Application No: FG/47/26/PD

Site Address: The Haystack Sea Lane Ferring BN12 5EP

Description of works: Prior approval under Schedule 2, Part 1, Class AA for the removal of existing roof, construction of new walls above existing walls to form new first floor walls and erection of new roof with a maximum height of 10.35m.

SECOND FLOOR PLAN | PROPOSED

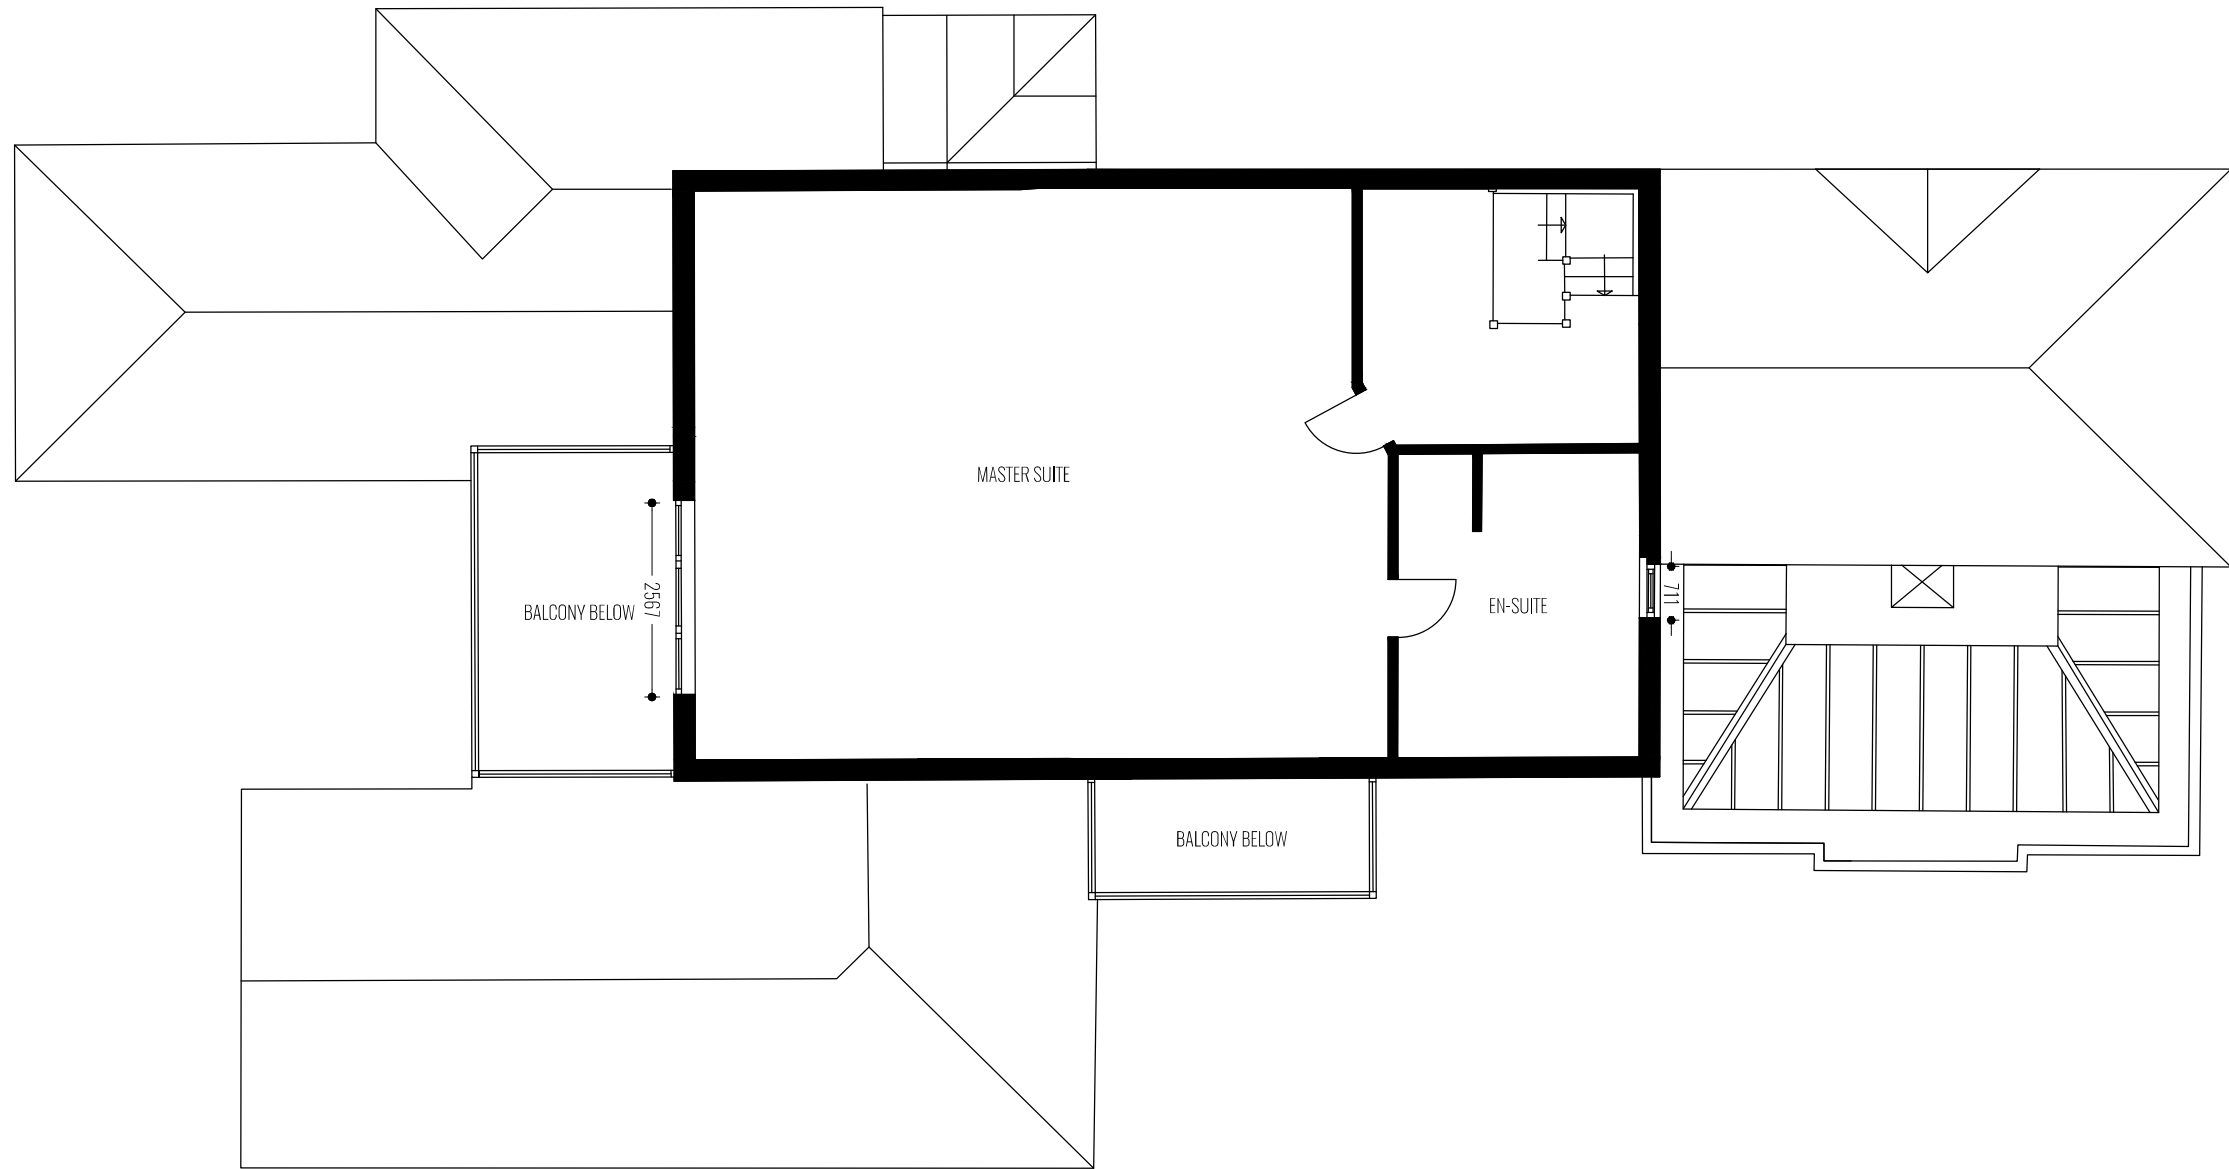
The proposal would increase the height of the existing dwelling through the removal of the roof and construction of a new first floor, reaching a maximum height of 10.35 metres. This would significantly increase the building's scale and massing, resulting in a development that appears disproportionately large and out of keeping with neighbouring properties.

The increased height, bulk and altered roof profile would disrupt the established character of the street scene. The proposal would fail to relate sympathetically to neighbouring properties and would erode the visual harmony and sense of place of the surrounding area.

The increase in height and massing would have a harmful visual impact from surrounding streets and neighbouring properties. The building would become an unduly dominant and intrusive feature, appearing out of character and affecting the visual amenity of the area.
